**Addendum No. 1**

RE: Contract # C204345

**Cabarrus County (Y-4810K)**

GRADE SEPARATION AT SR-1625 (ROGERS LAKE RD) OVER NS/NCRR  
AND CLOSURE OF AT-GRADE CROSSING #724408Y IN KANNAPOLIS.

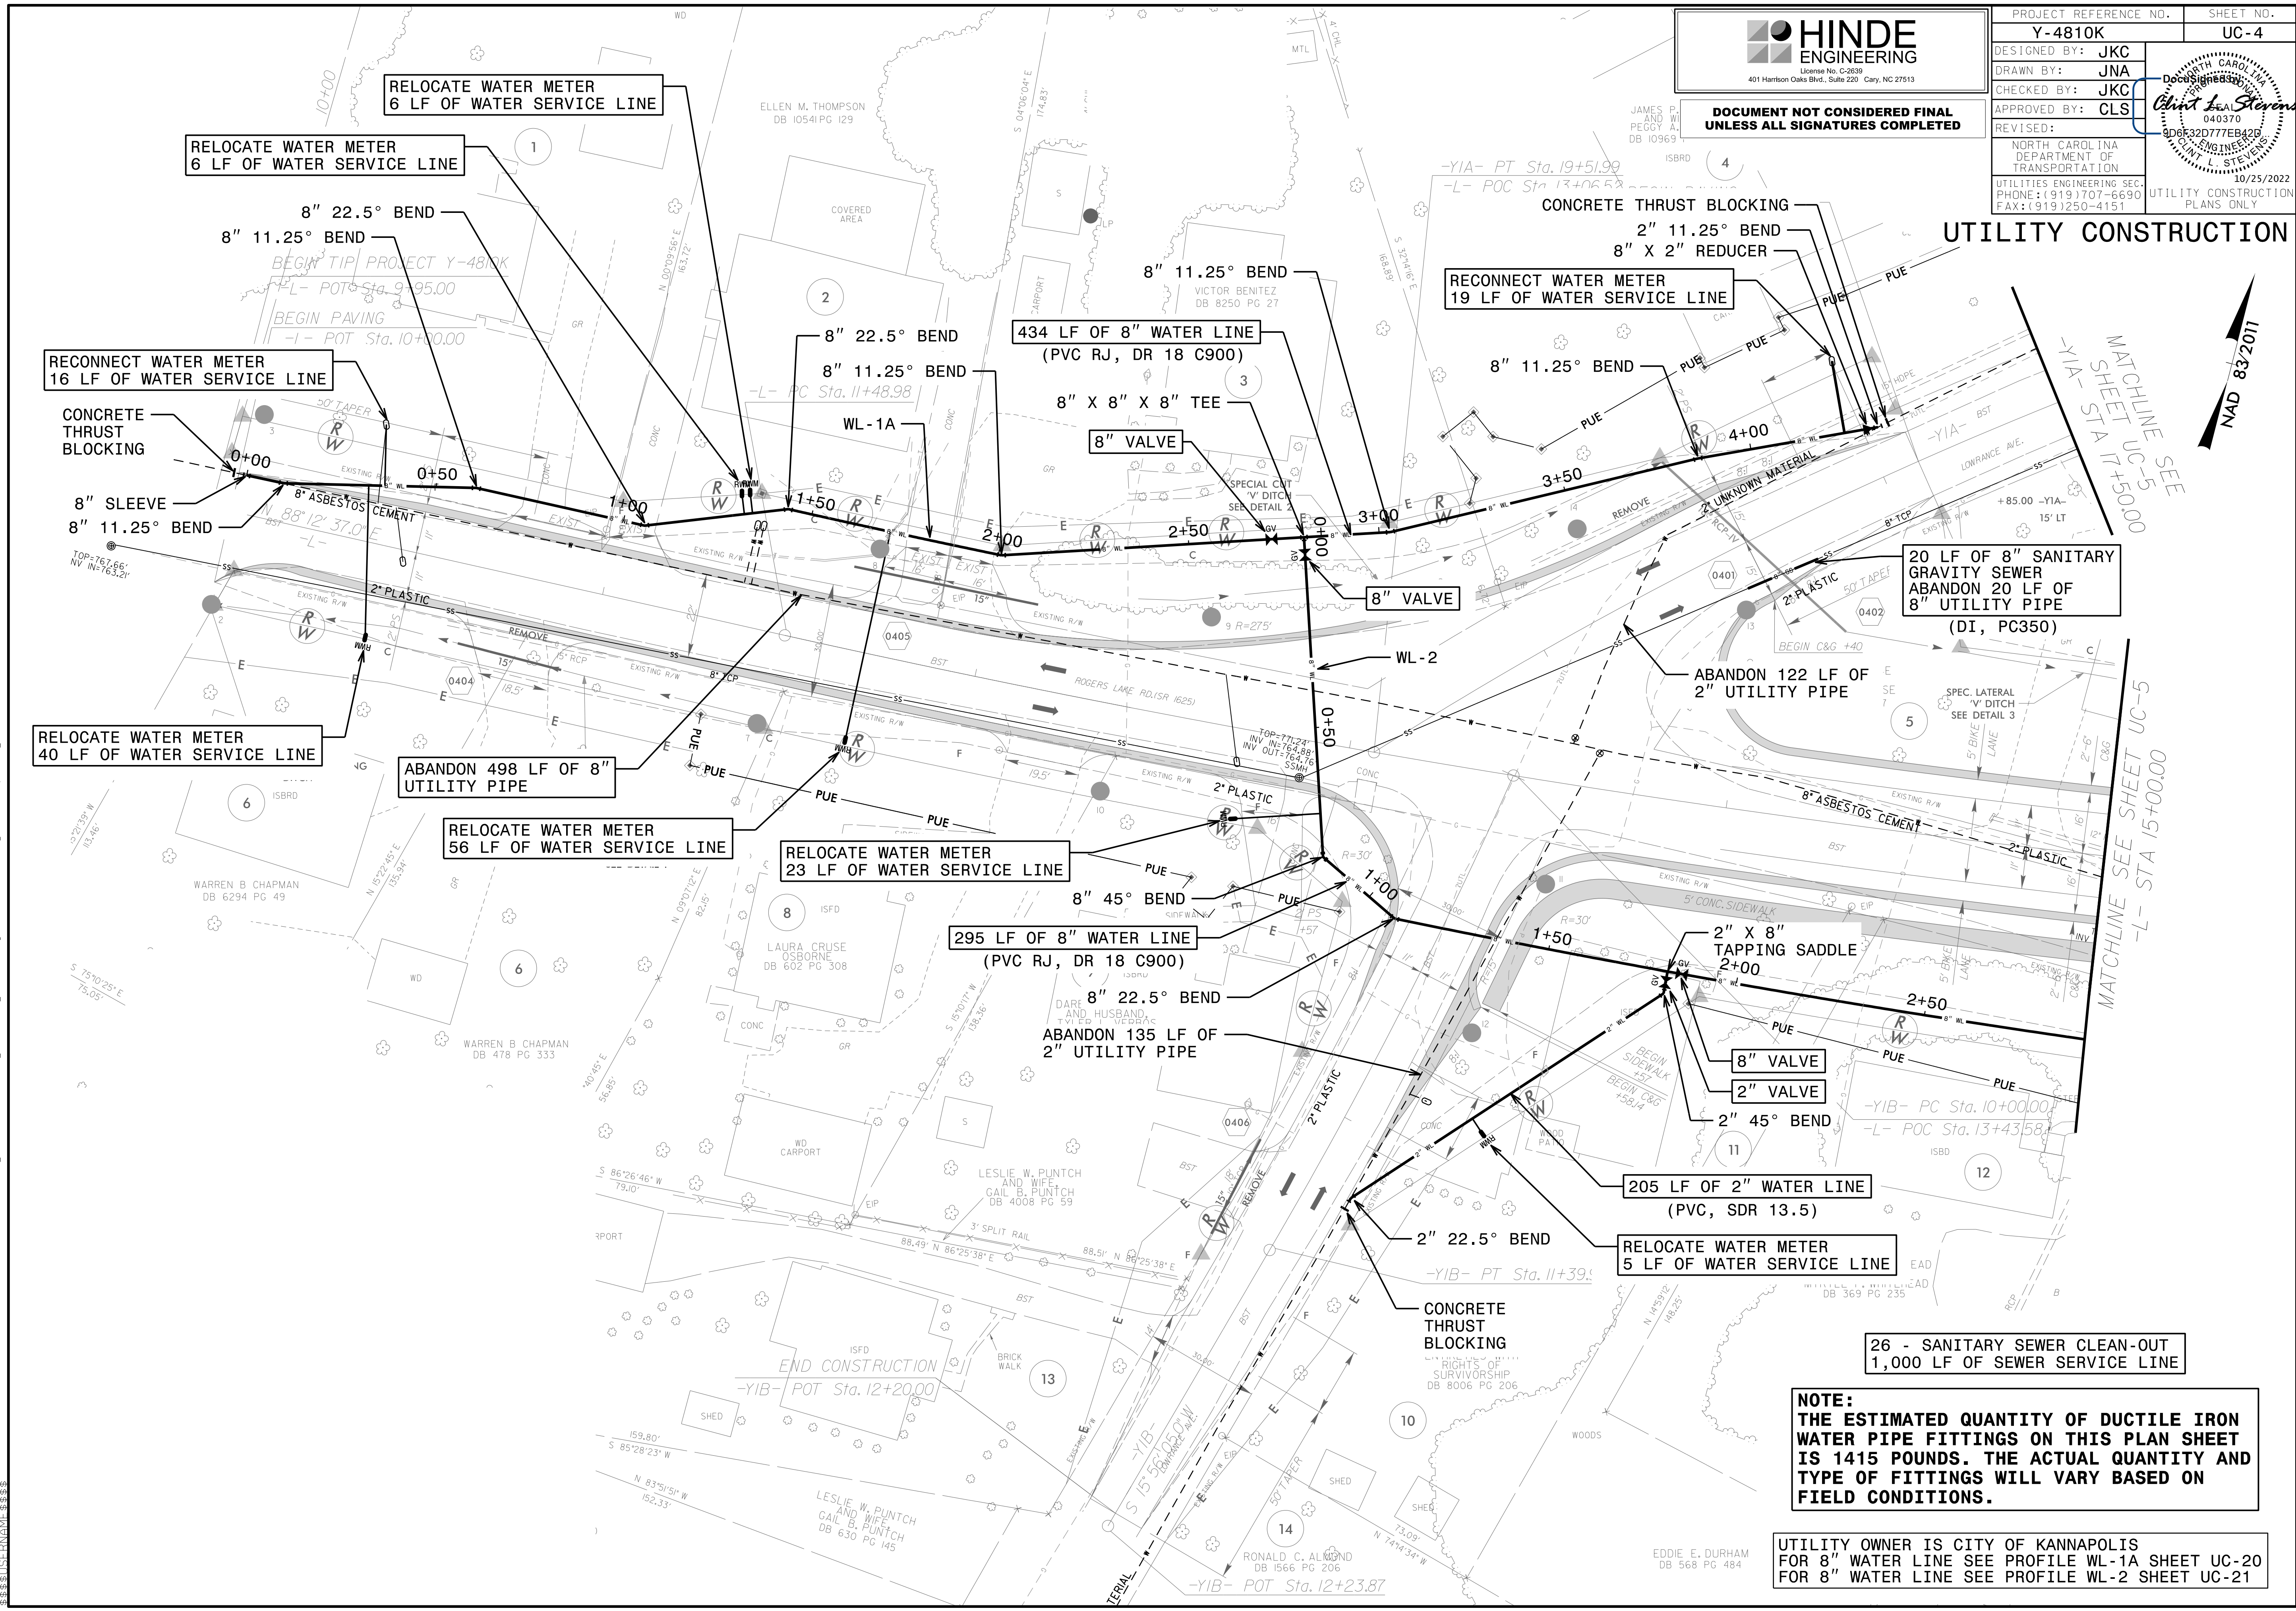
Sheet No.	Revision
UC-4	Added one 8-inch Valve per NCDEQ comment on WL-2 STA 1+80.
UC-18	Added one 12-inch Valve per NCDEQ comment on WL-4 STA 5+40.
UC-21	Added valve per sheet UC-4.
UC-22	Added valve per sheet UC-18.
UC-23	Adjusted WL-4 profile at STA 11+60 to show proper clearance with existing gas per NCDEQ comment.
